HARRIMAN ASSOCIATES

A D D E N D U M

Date May 20, 2005
From Harriman Associates
To Prospective Bidders
Re Addendum No. 2 to the Bidding Documents for:

Maine Heart Surgical Associates
Portland, Maine

Drawing Number
E20.2

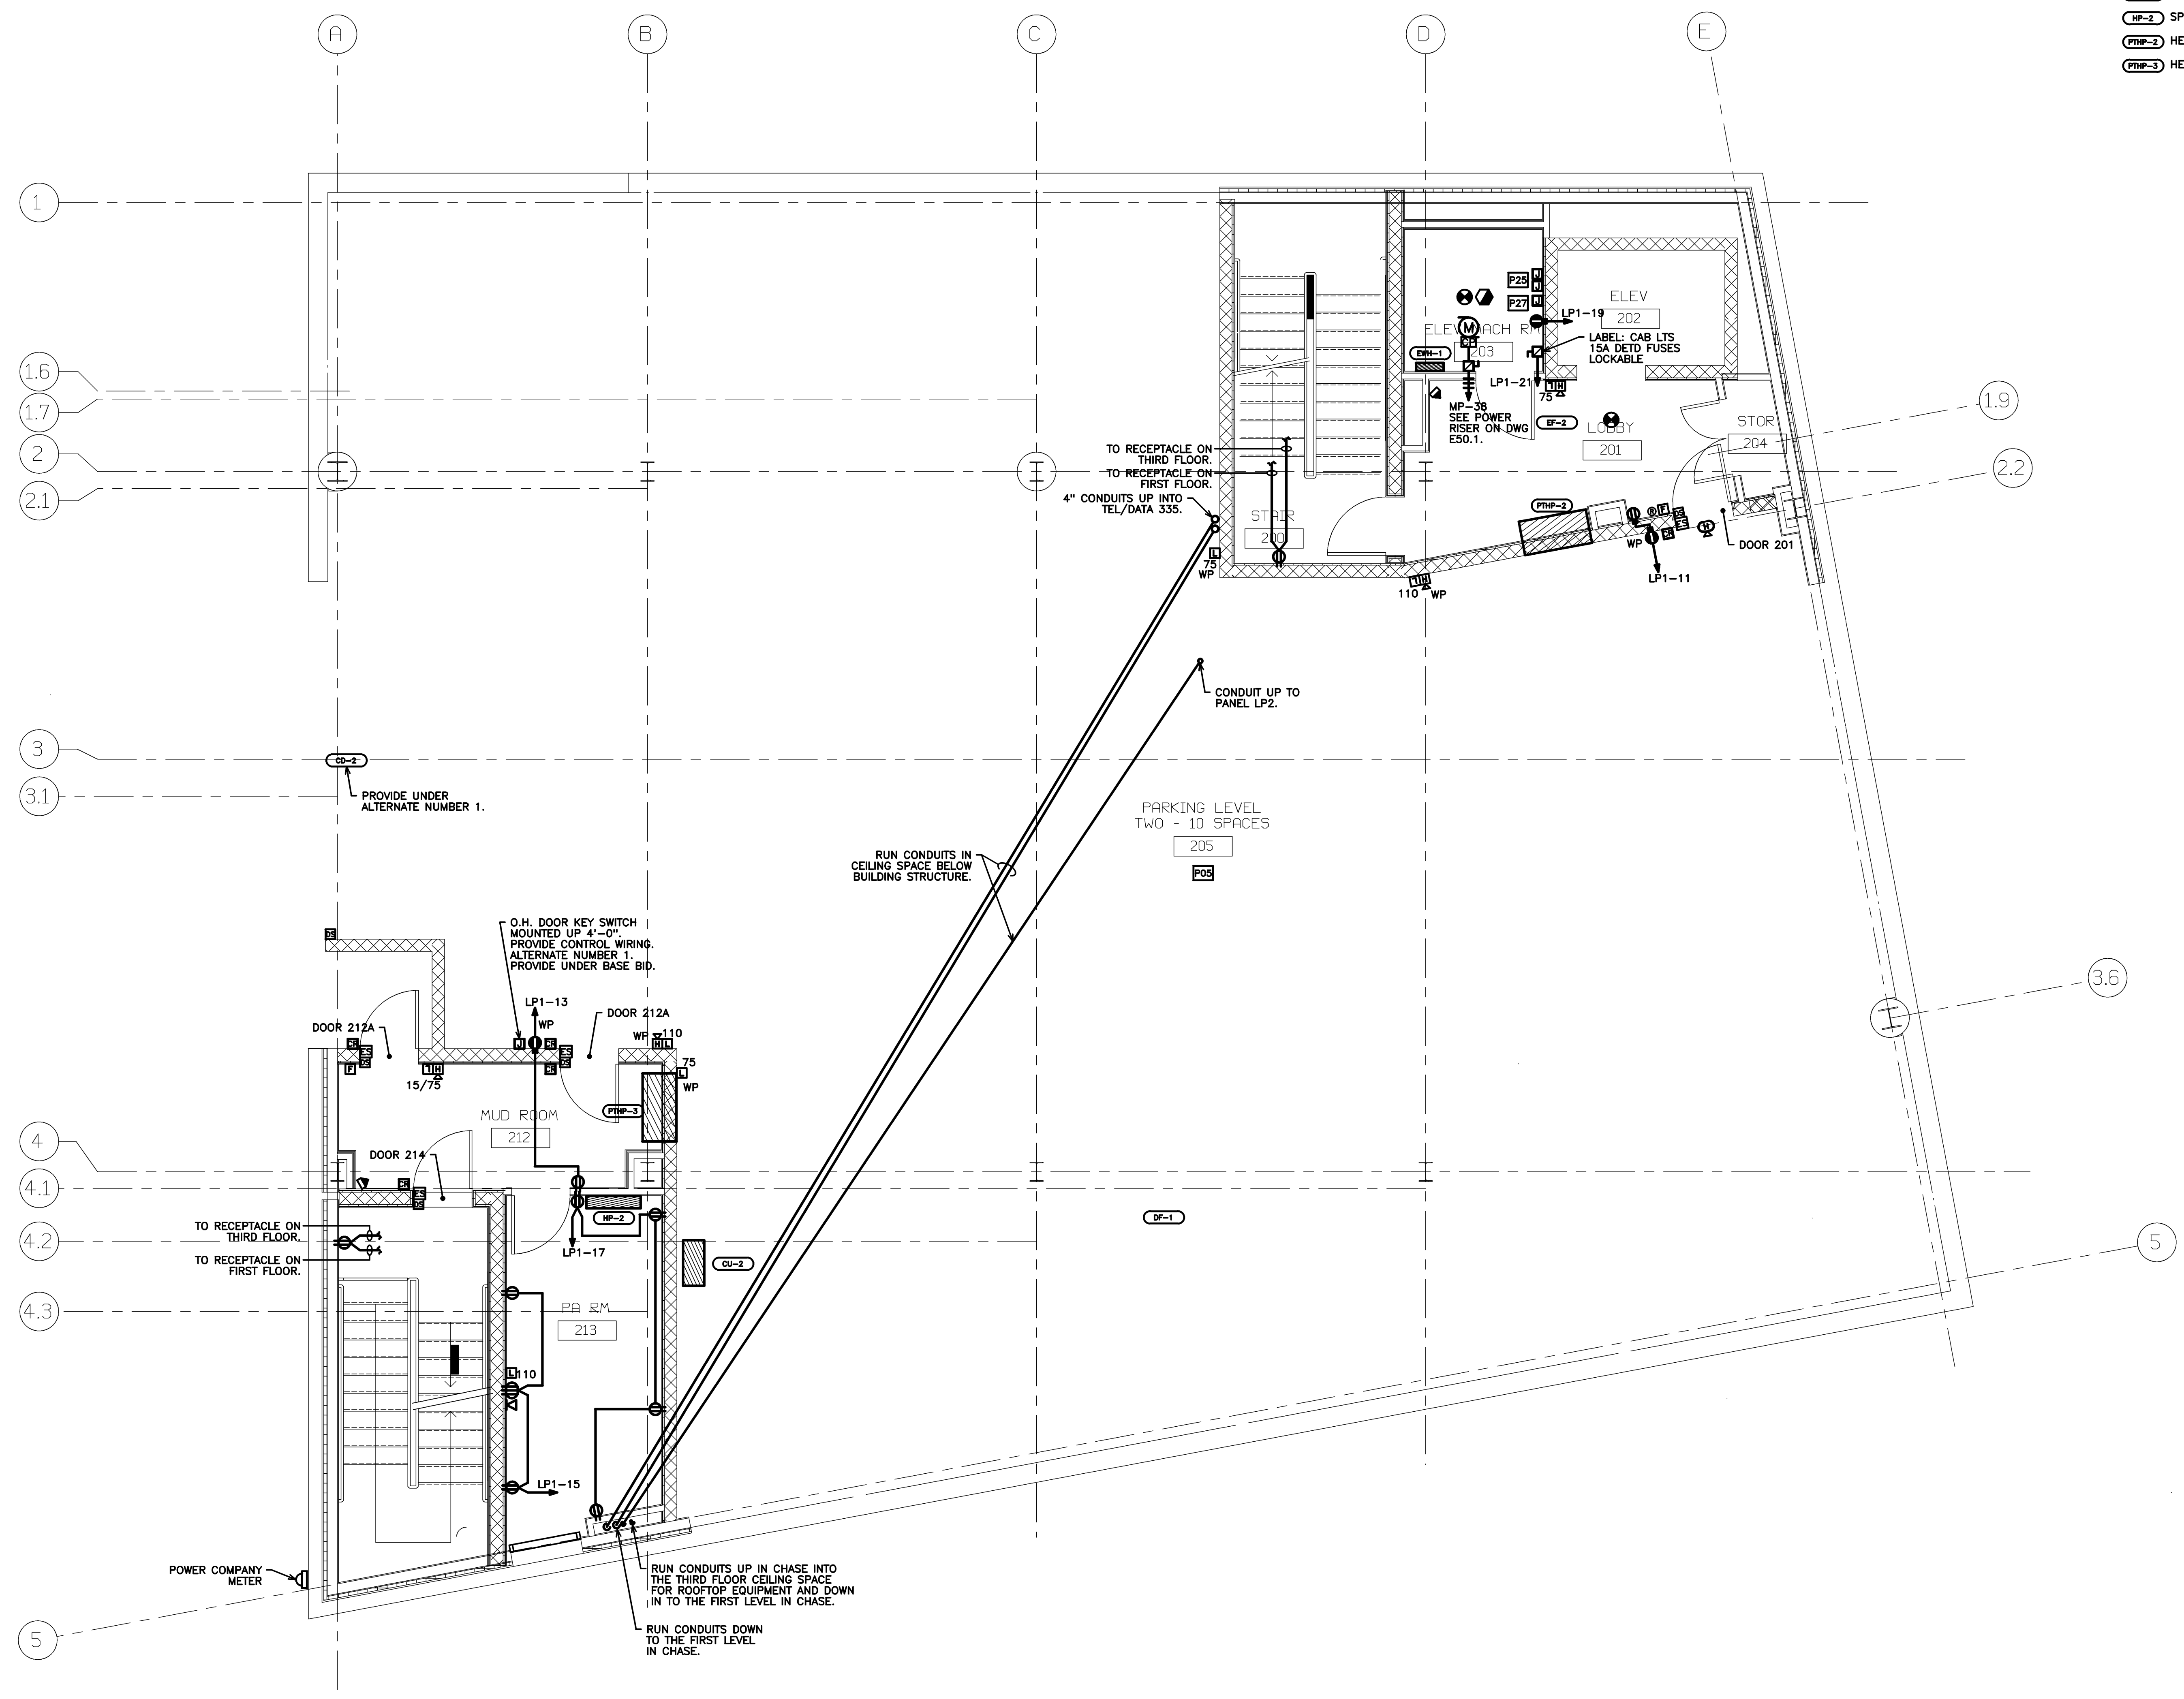
- a. Stair 200 – Relocate duplex convenience receptacle from the south wall to the west wall at the second floor landing.
11. DRAWING E20.3 – THIRD FLOOR PLAN – POWER

E20.3

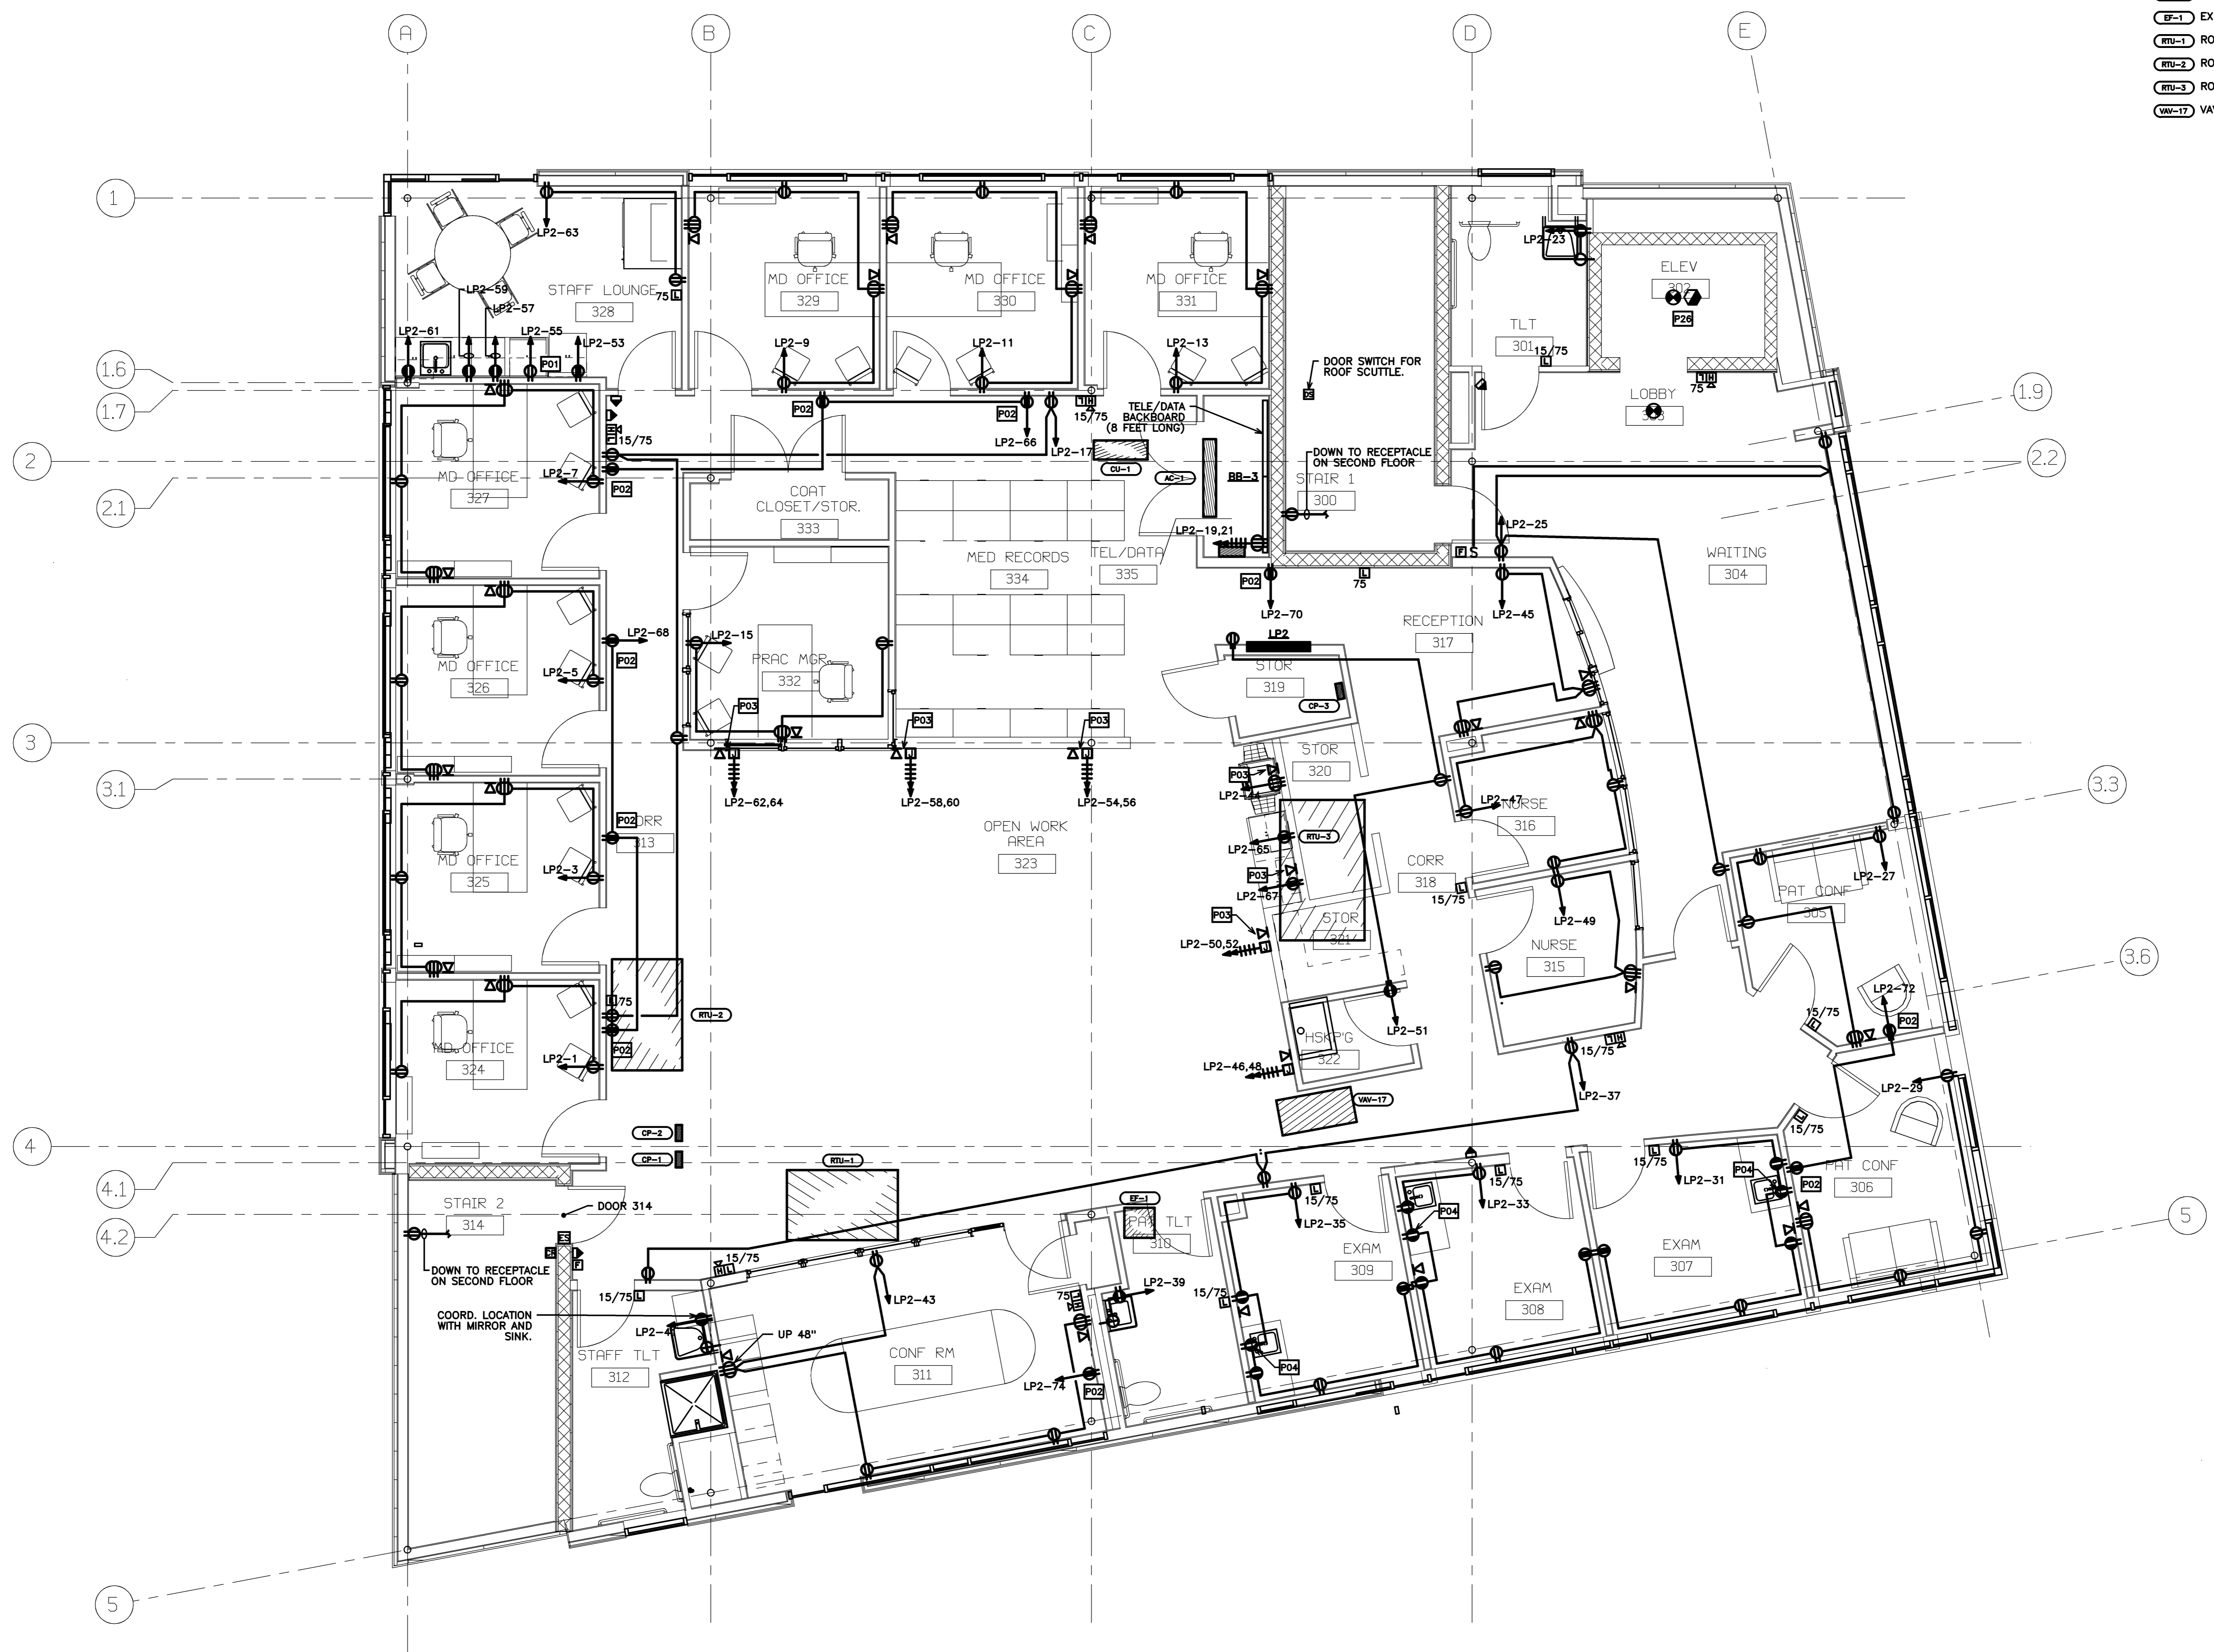
- a. Lobby 303 – Relocate duplex convenience receptacle from hinge side of door exiting Stair 1 two feet to the east.
 - b. Lobby 303 – Relocate single pole switch from the hinge side of door exiting Stair 1 to the latch side.

- c. Lobby 303 – Relocate fire alarm pull station from the hinge side of door exiting Stair 1 to the latch side.
 - d. Reception 317 – Relocate fire alarm strobe light unit from the north wall to the west wall.

- e. Reception 317 – Add fire alarm strobe light unit to same wall as power panel LP2.
 - f. HSKP’G 322 – Relocate GFCI duplex convenience receptacle to the south wall.

SECTION **D4**
 3/4" = 1'-0"
 REF: S20.1

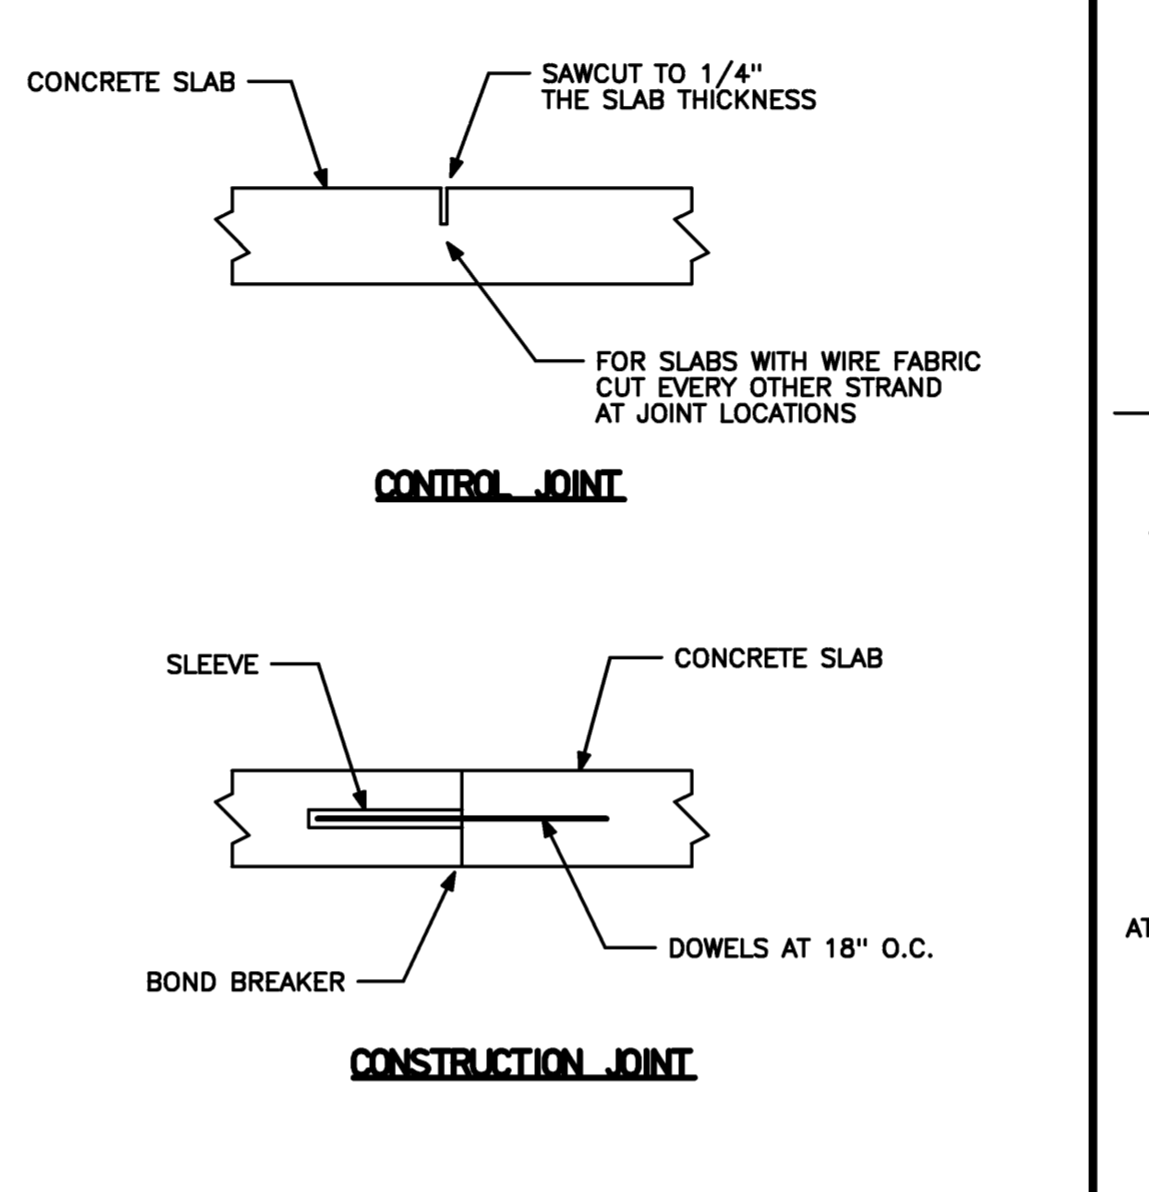
1. ADDENDUM 1 - CHANGES TO DRAWING
 - A. SKA3 - SECTION
 1. Change name, "Section" to read, "Revised Section D4/S50.1"
